Our Ref: LU/257/18/HH
Your Ref:

Town & Country Planning Act 1990 (as amended)
Town & country Planning (Development Management Procedure) (England) Order 2015
Application for Planning Permission for Works or Extension to a Dwelling

Development Installation of crossover and hardstanding
Location 21 Beaumont Park Littlehampton

LOCATION PLAN 1:1250

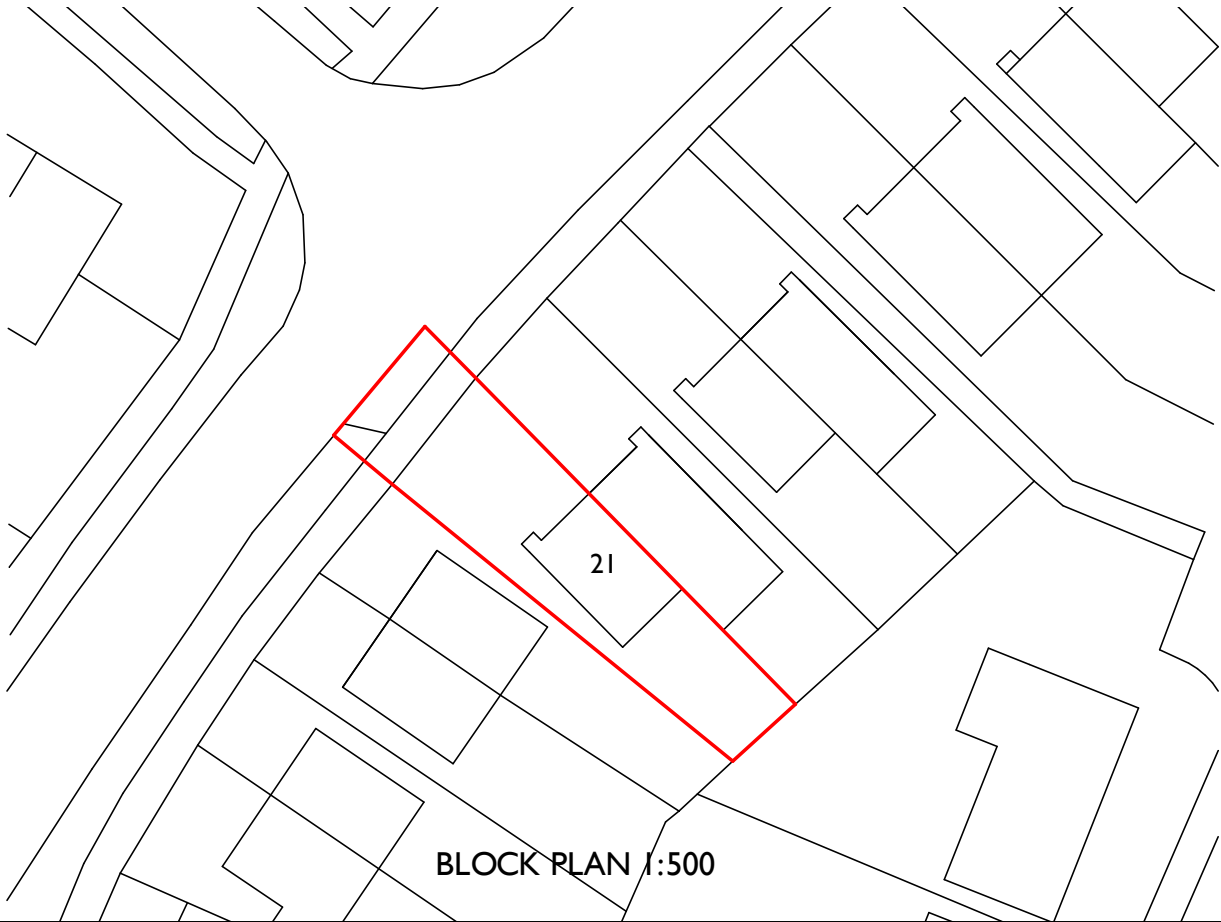
The site to which the application relates needs to be outlined in red.

Drawing Title:
Existing and Proposed Site Plans

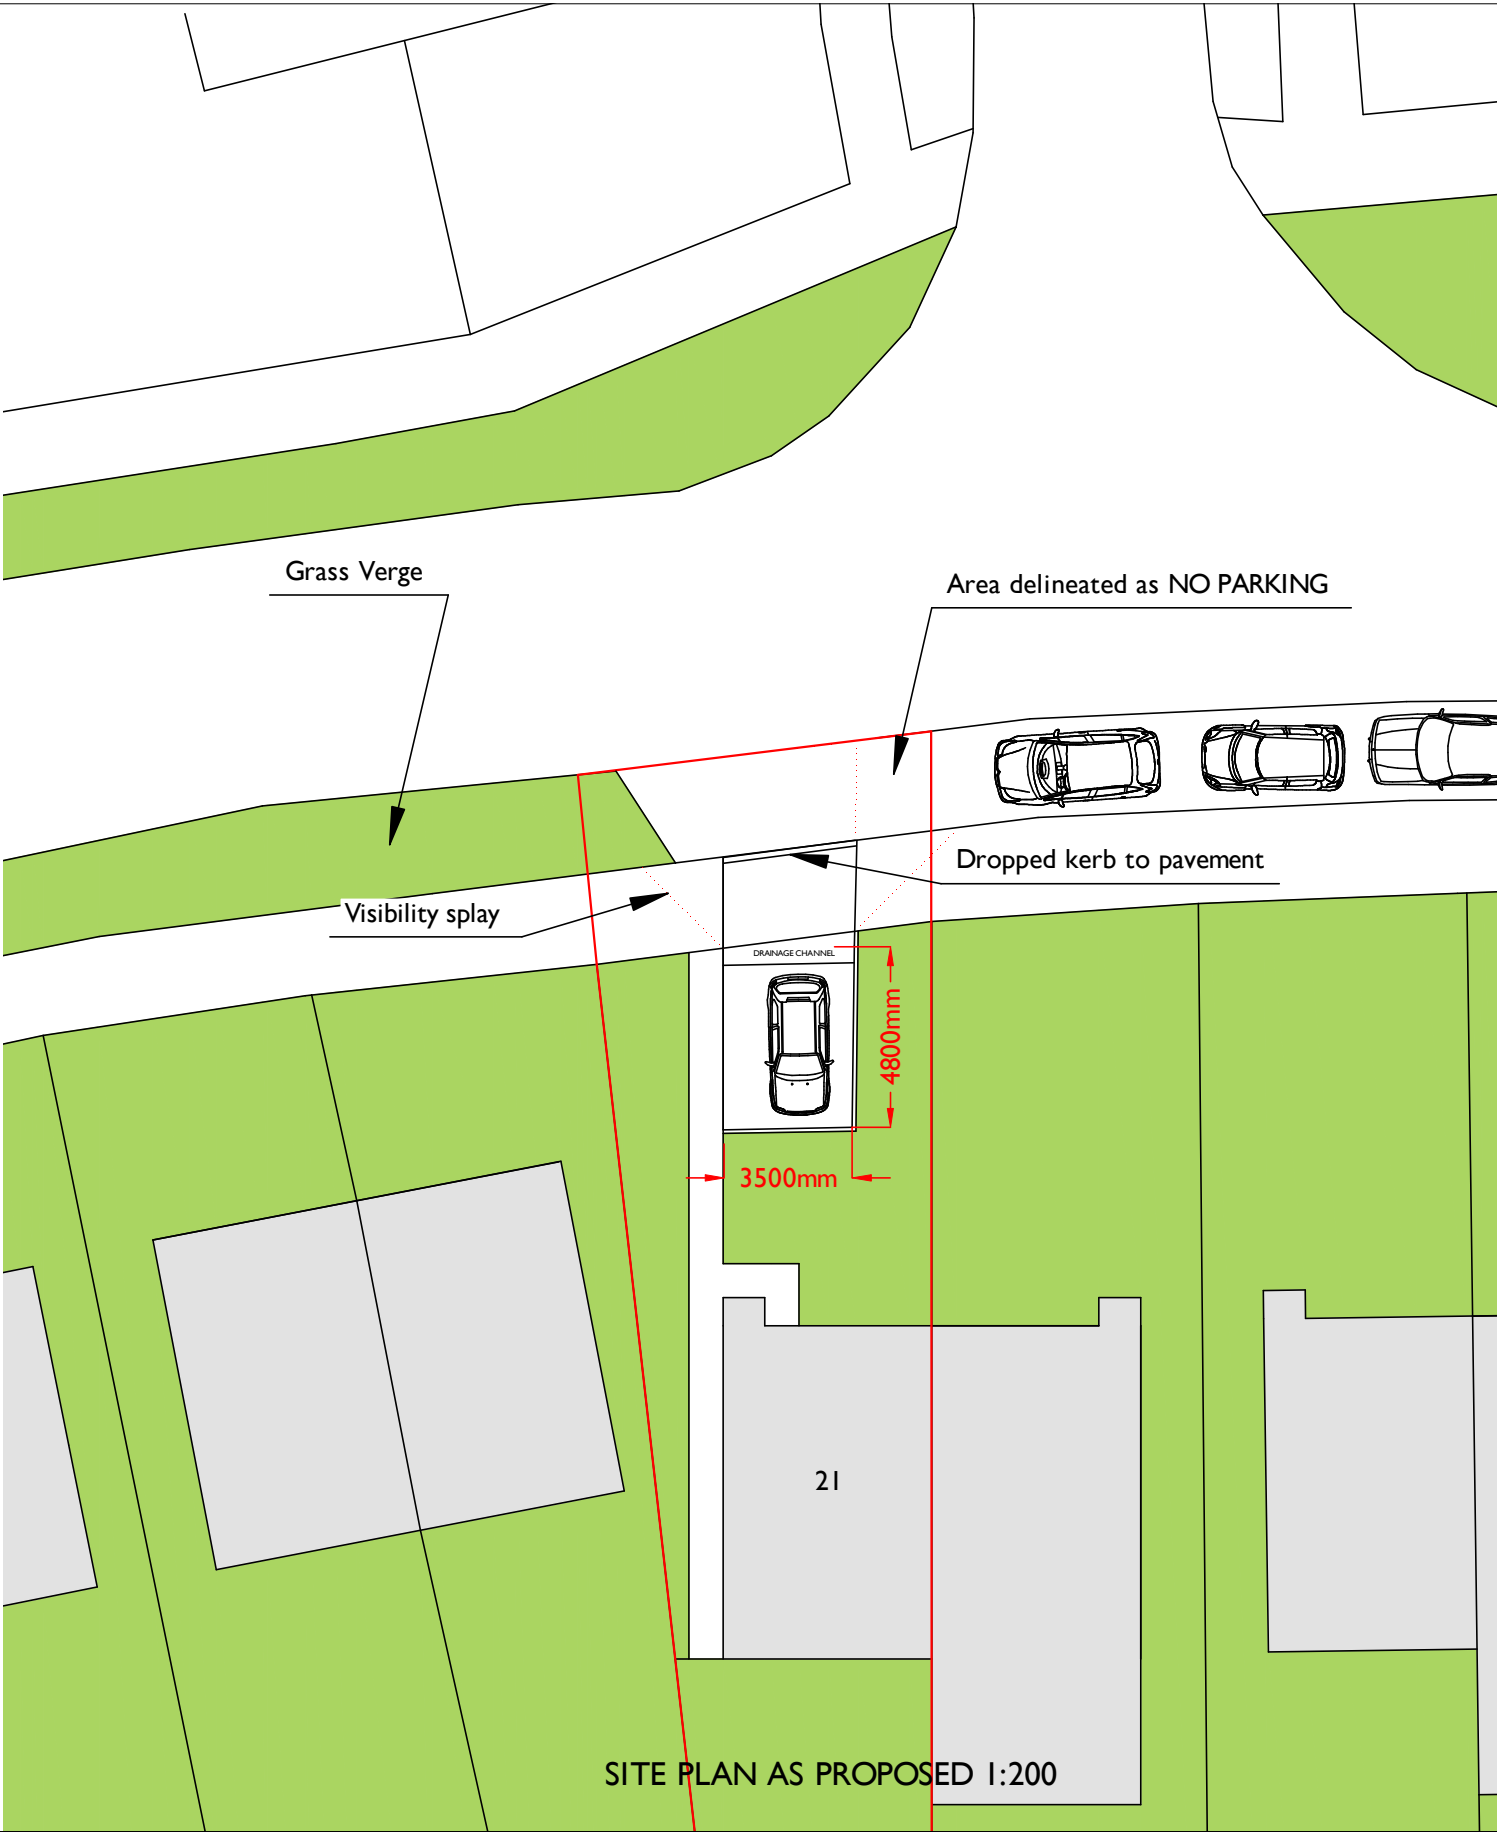
Please submit 1 electronic or 3 paper copies of clearly labelled existing and proposed site plans at a scale of 1:50, 1:100 or 1:200. Further details can be found in the National Validation Requirements.
